Planning Application No: 3/2025/0194

Proposal: Proposed conversion of garage to form additional living space. Addition of window to

Location: 27 Poplar Way Barrow BB7 9ZN

EXISTING AND PROPOSED SITE PLAN.

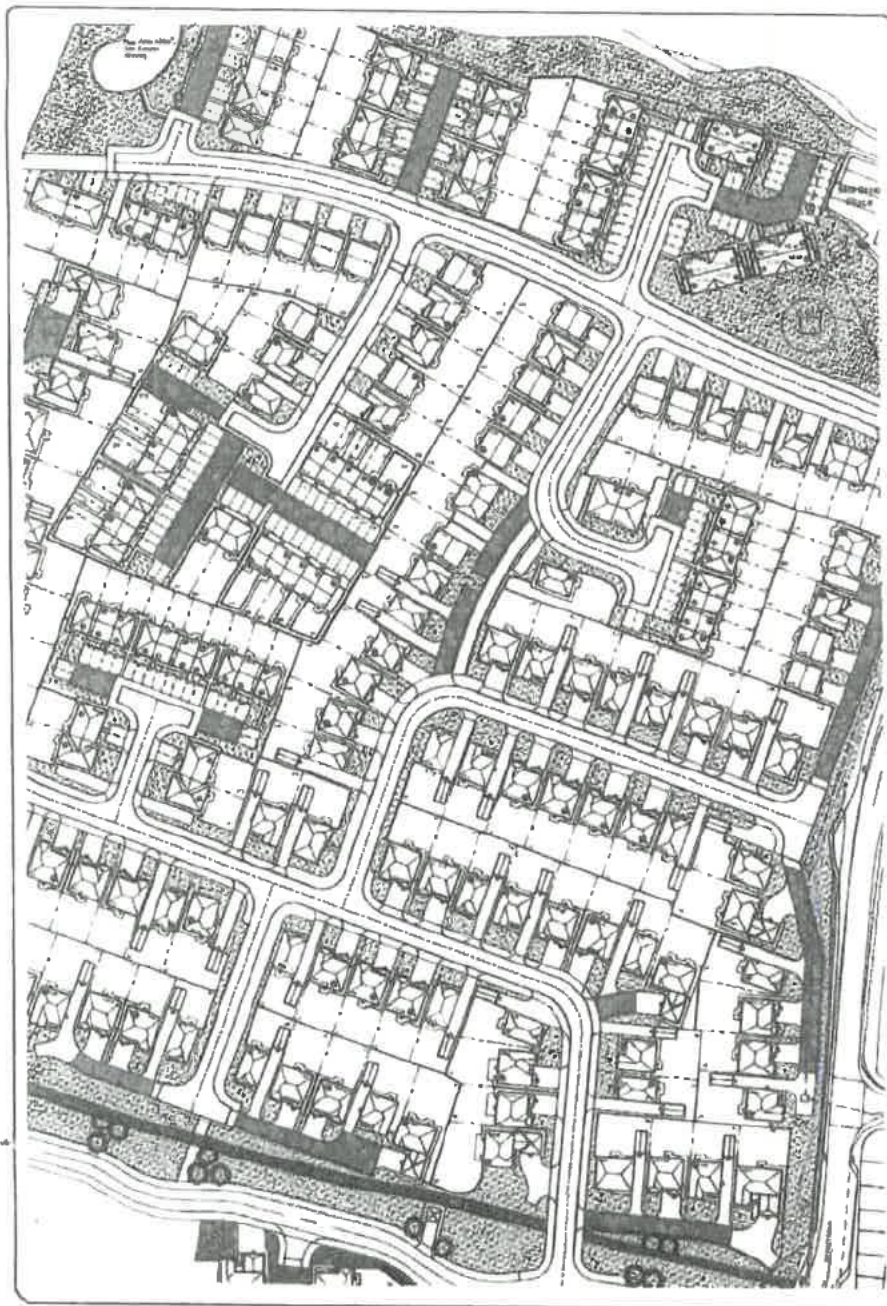
Further to the additional information on the clarification emails dated 8.5.25 and 9.5.25, a covered cycle store is required for 4 bicycles to promote sustainable forms of transport and aid social inclusion.

Prior to the first occupation a secure, covered cycle store for 4 cycle spaces shall be provided. Reason: To promote sustainable forms of transport and aid social inclusion.
